# Cathedral Rock Commons Commercial Grading & Erosion Control Plans El Paso County, Colorado

PCD FILE NO. SP221 / SF2210

C3.1

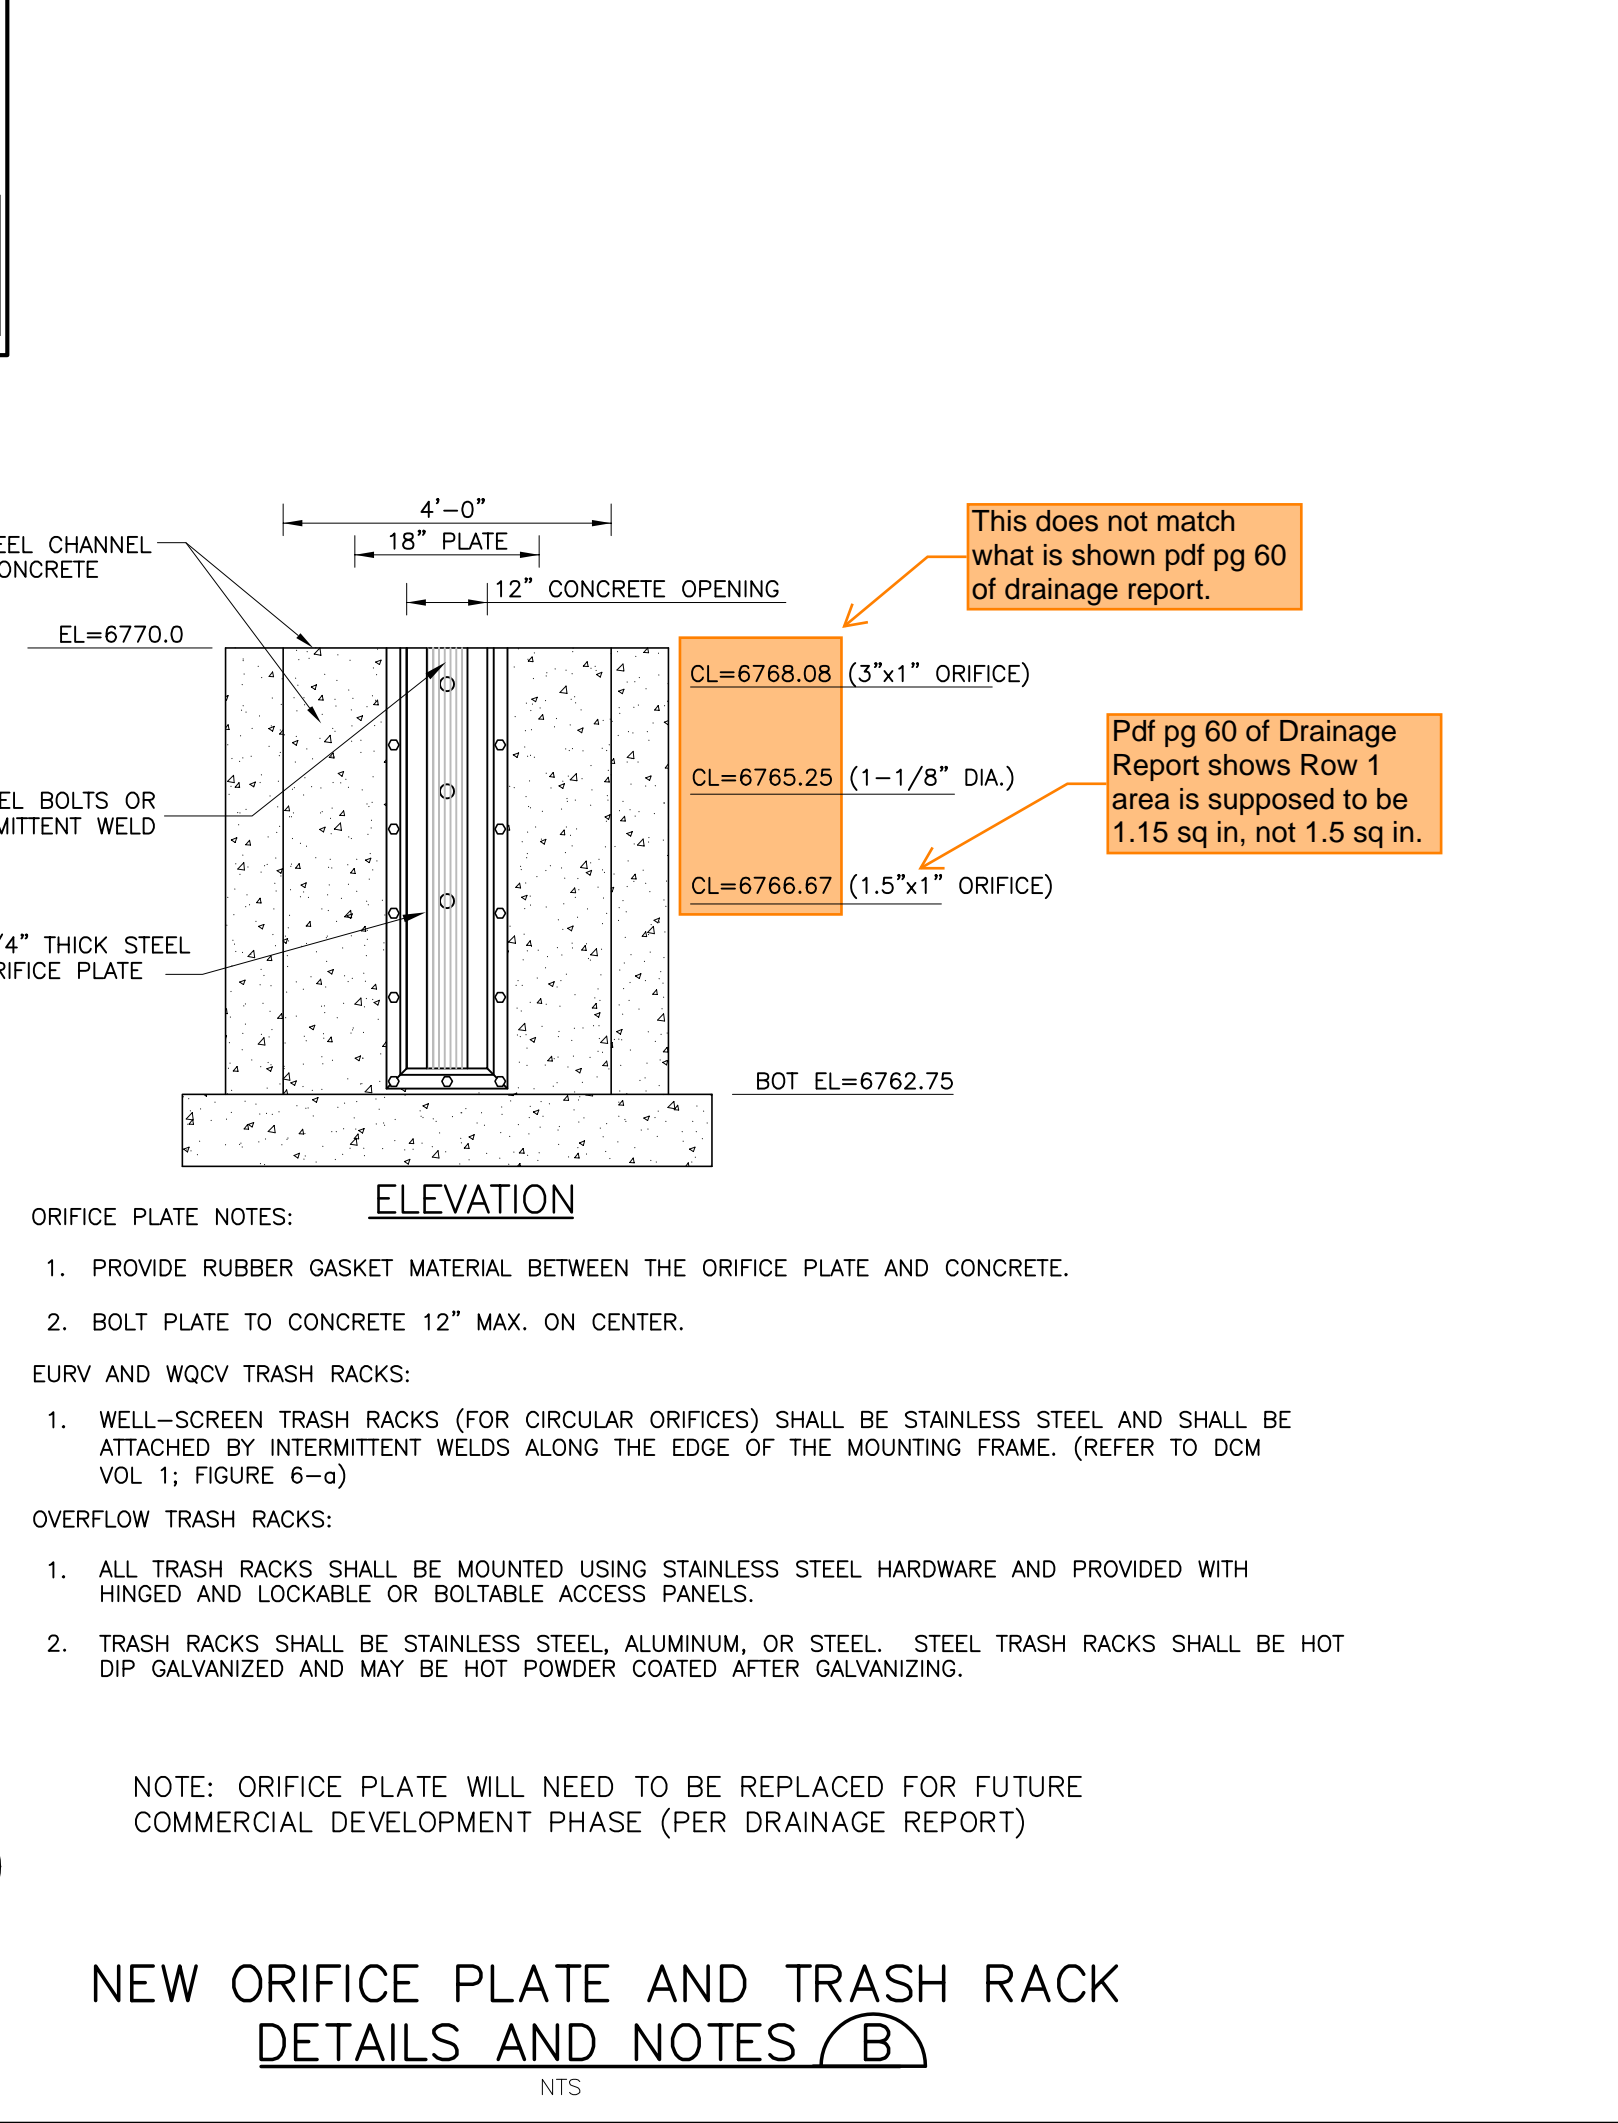
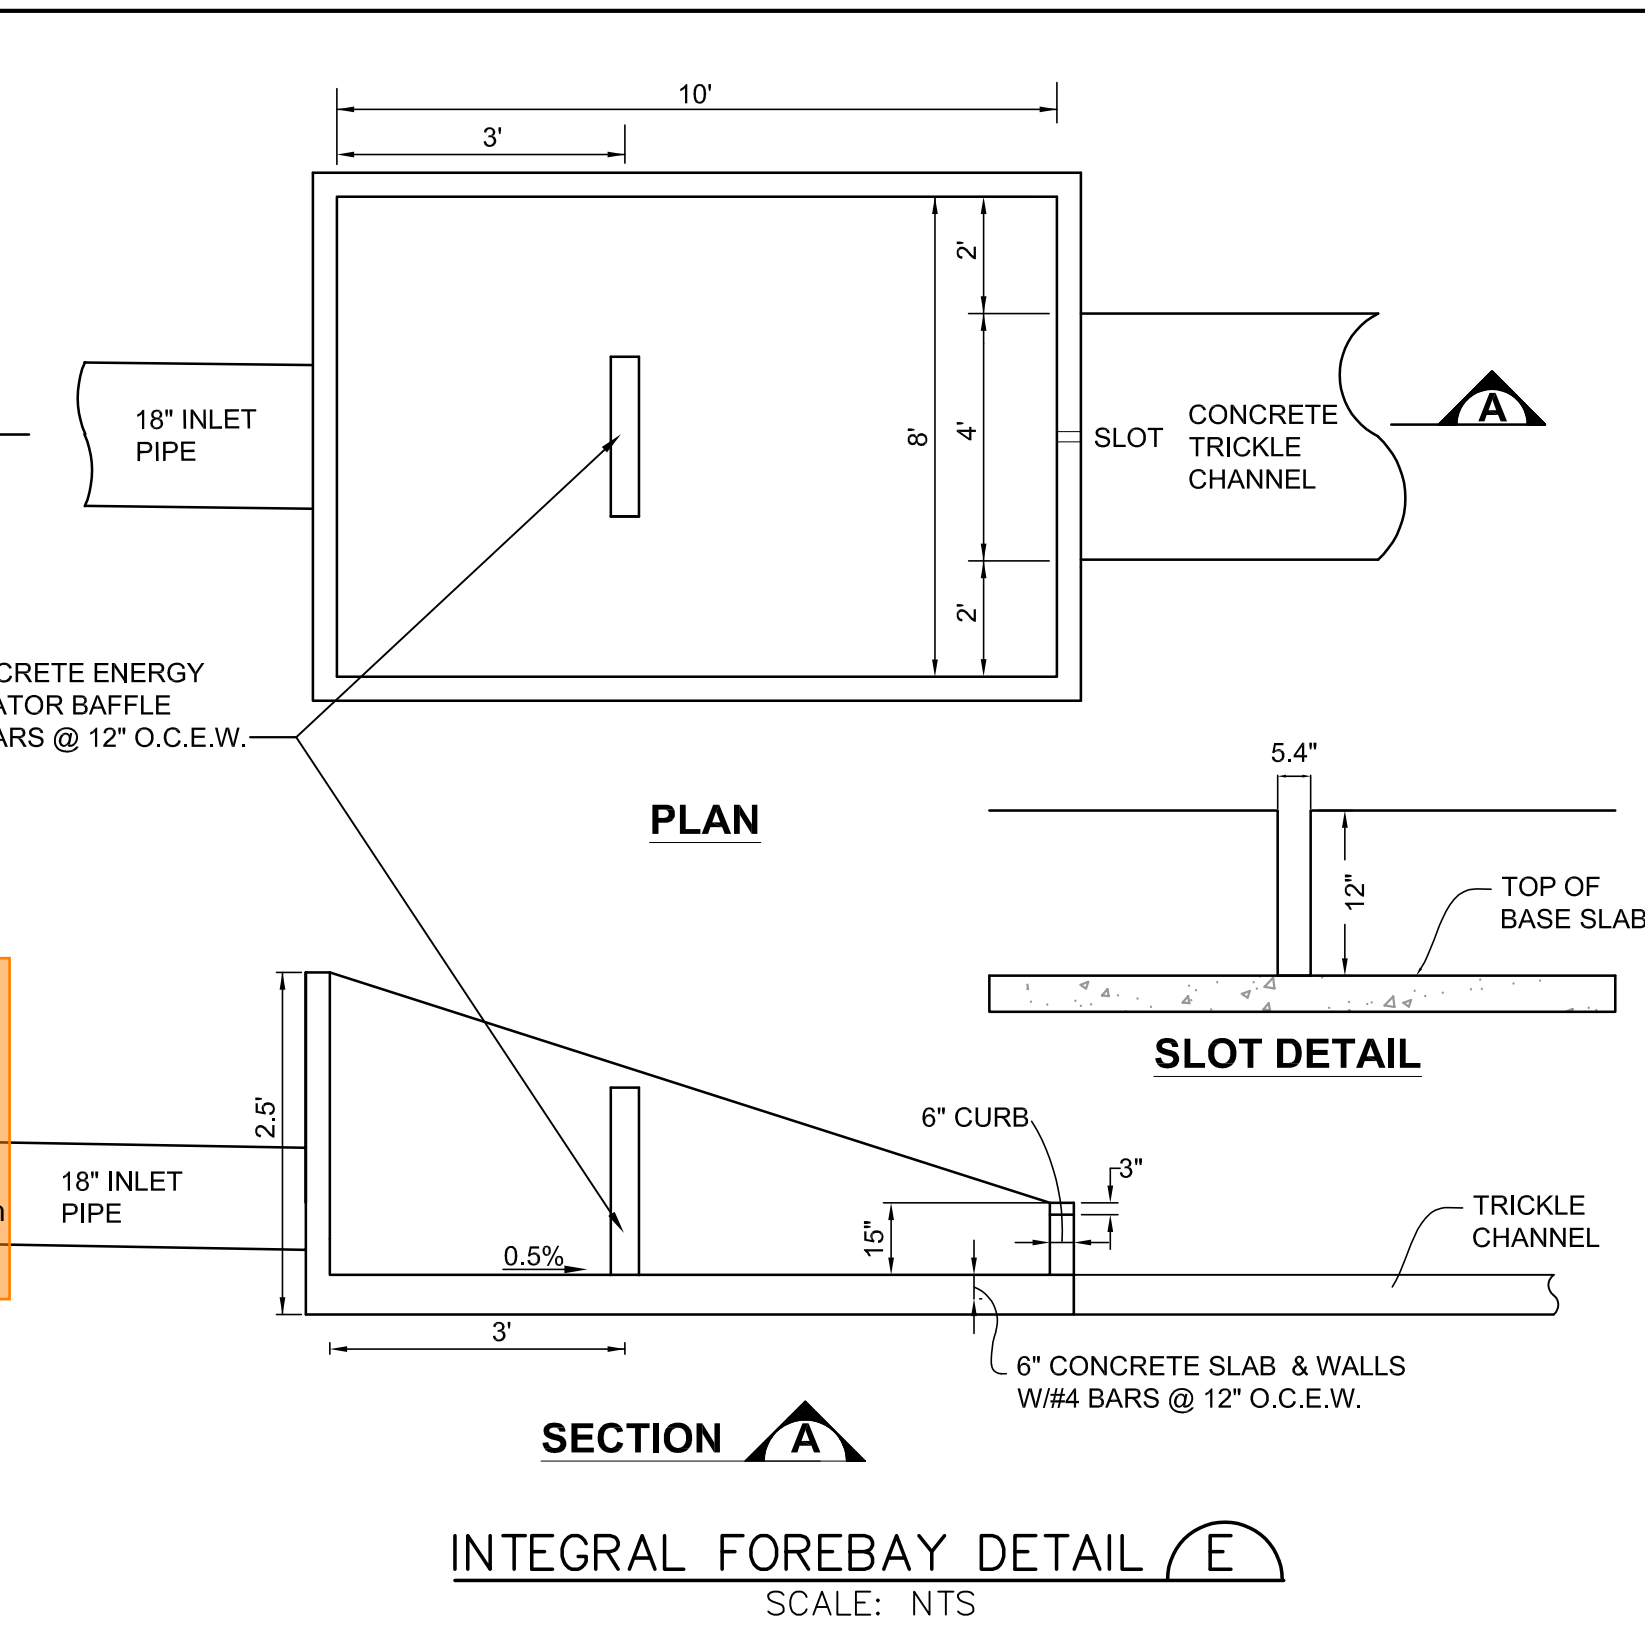
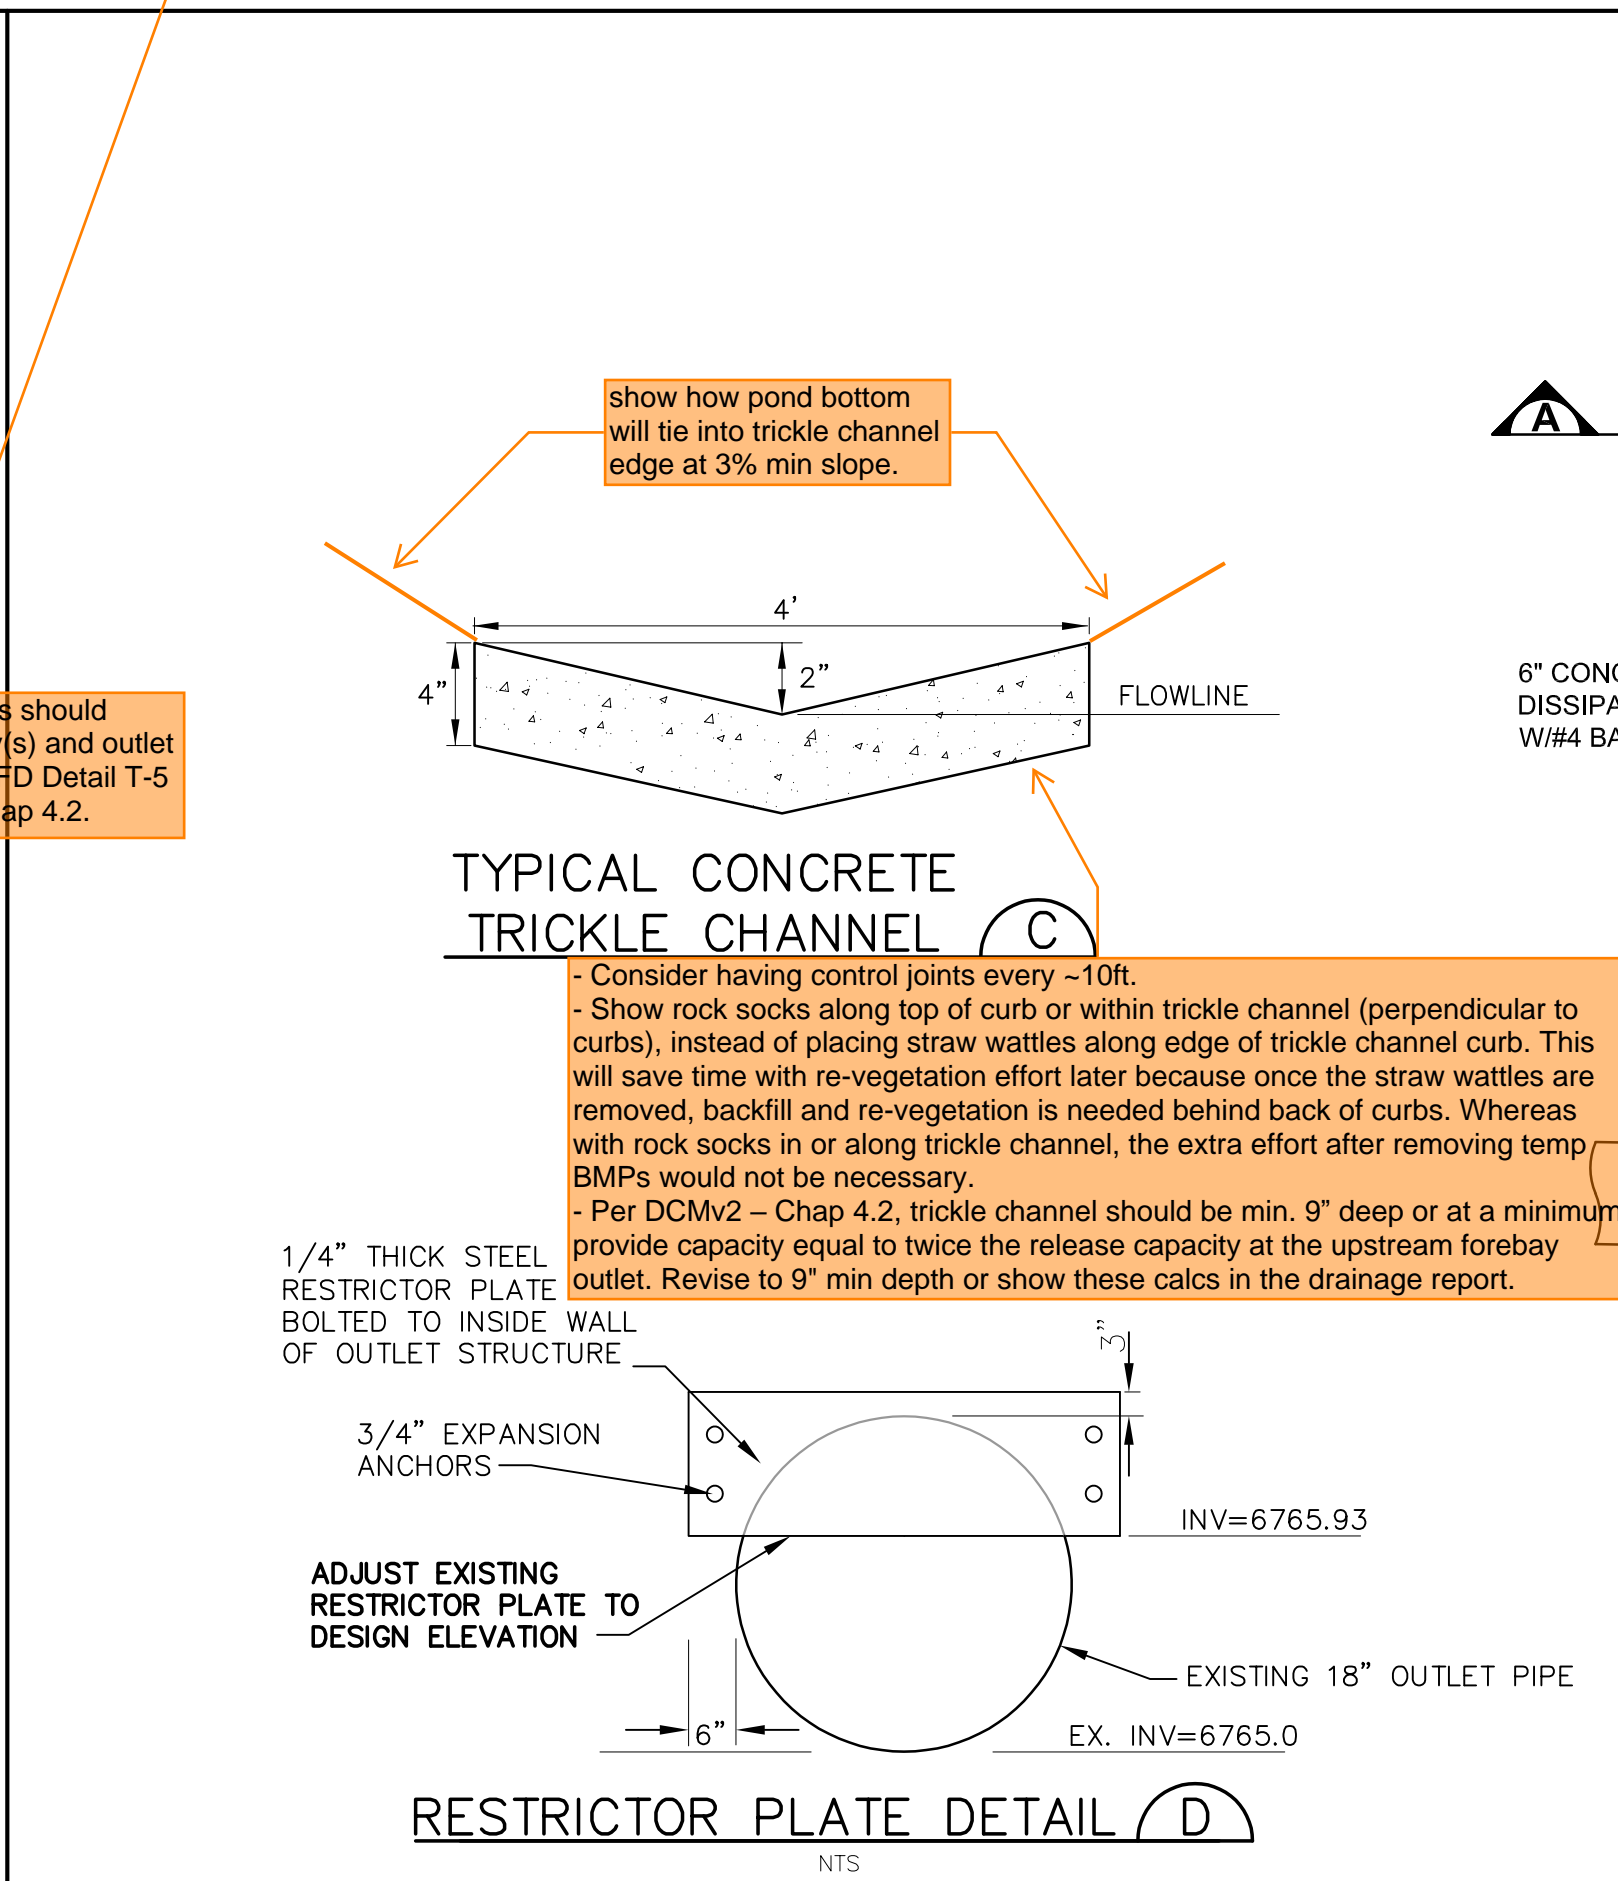
Text callout not updated to say "12%"
